Your Ref: OWPC23673
Our Ref: EP/67/19/HH 10-06-2019
Please ask for:
Zac Denton

Single storey side and rear extension with loft conversion and conversion of garage to habitable use

Kilve Kingston Lane East Preston

Proposed Roof Plan and Section

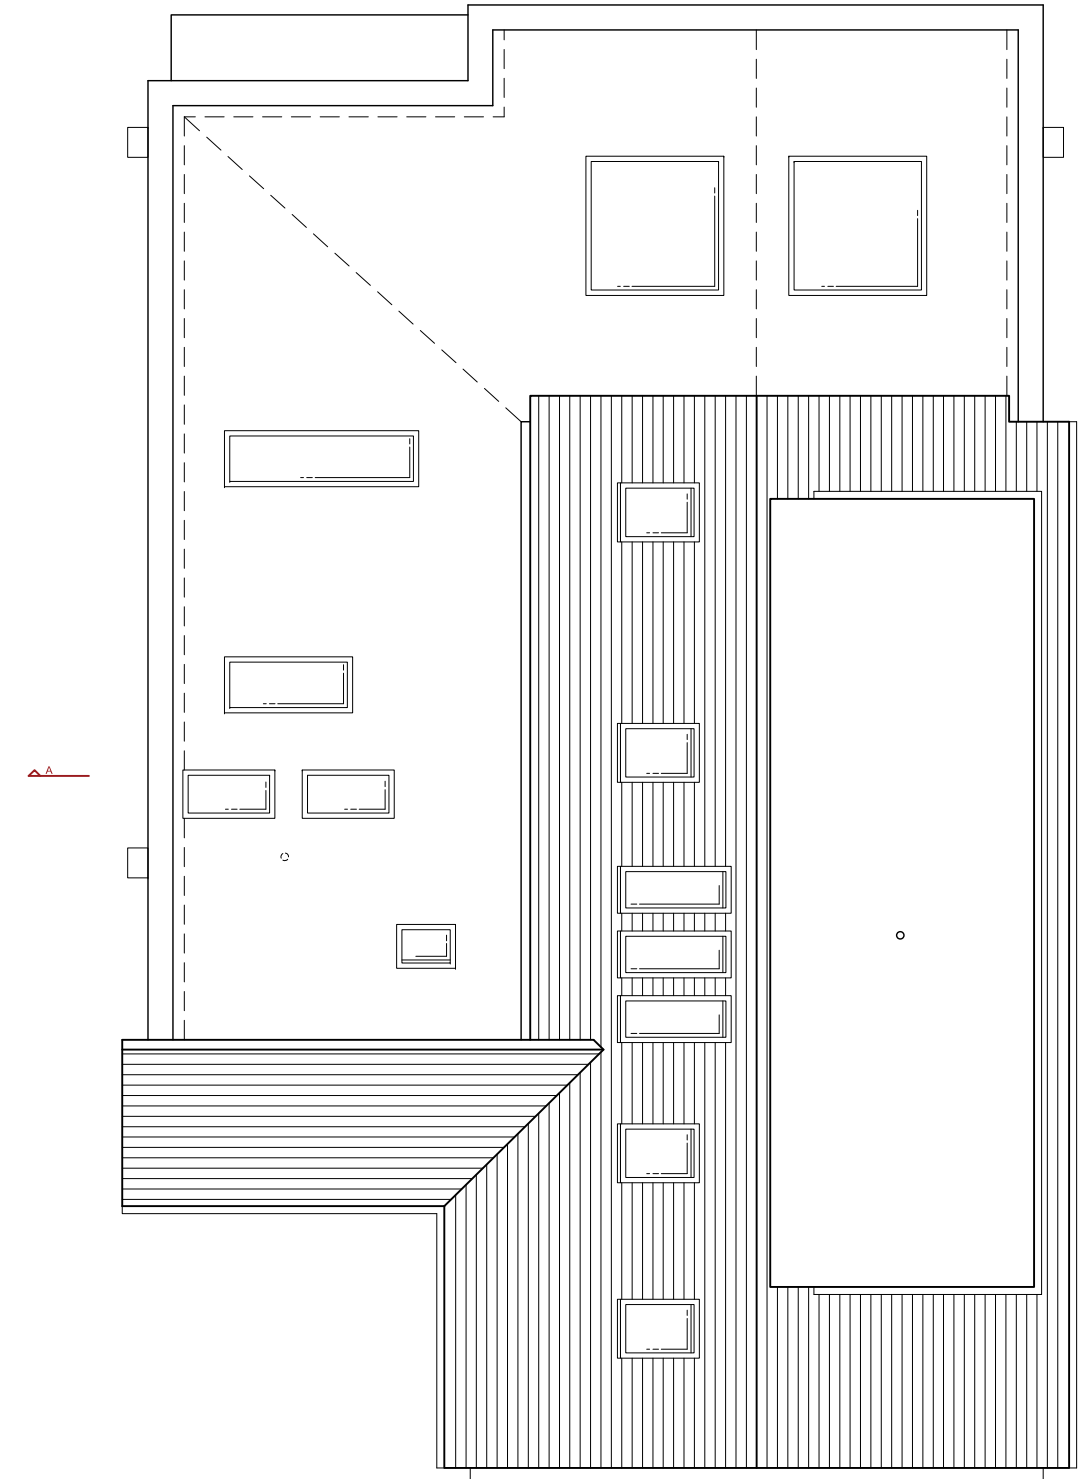
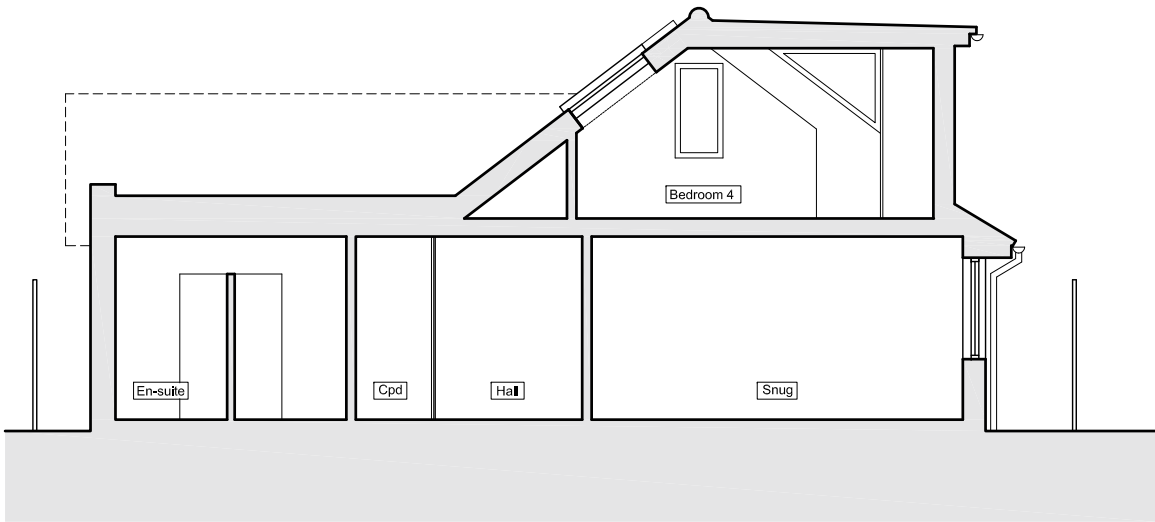
The proposed extensions to this bungalow are clearly incompatible with policy D DM4 of the Arun Local Plan and policy 1 of the East Preston Neighbourhood Plan. The existing bungalow would virtually disappear behind the large dormer and the large rear extension. This rear extension is not visually integrated with the existing building in either style or materials. The dormer would extend along more than 70% of the length of the roof and reach almost to the ridge. The proposed materials do not reflect the materials used in surrounding buildings.

The rear extension and the dormer, because they are not visually integrated with the existing building and are not visually subservient to it, are incompatible with policy D DM4. The dormer, because it is not subservient to the appearance of the roof as a whole, is incompatible with policy 1 of the Neighbourhood Plan. The proposed materials are incompatible with policy D DM1 and DM4, and policy 1 of the Neighbourhood Plan.
